[REDACTED] Kathryn <Kathryn.Walsh@lancashire.gov.uk>
Sent: 01 August 2025 09:29
To: Maya Cullen <Maya.Cullen@ribblevalley.gov.uk>
Subject: D3/2025/0394 - 21 Berry Lane Longridge - Response

I am currently reviewing application 3/2025/0394 at 21 Berry Lane Longridge and I do have some concerns regarding the proposed gates on the side street. The current location is unsuitable and would likely result in an obstruction of the highway while vehicles wait for the gates to be operated.

Proposed Site Plan 1:200

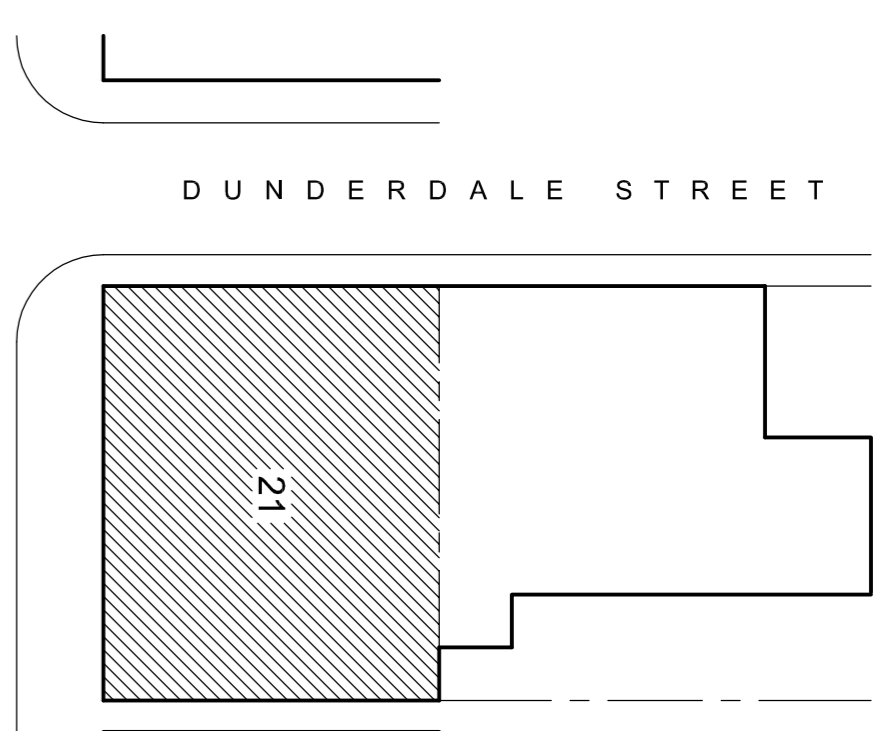
The gates would need to be set back a minimum of 5m behind the adopted highway, which in this case the adopted highway is likely to be up to the back of the footway on Berry Lane.

There are also a number of other properties along Dunderdale Street which will require emergency vehicle access, deliveries, refuse collection, etc. and there is no information on how

this would be managed, and the area does not fall within the applicant's red edge and as such, ownership concerns exist.
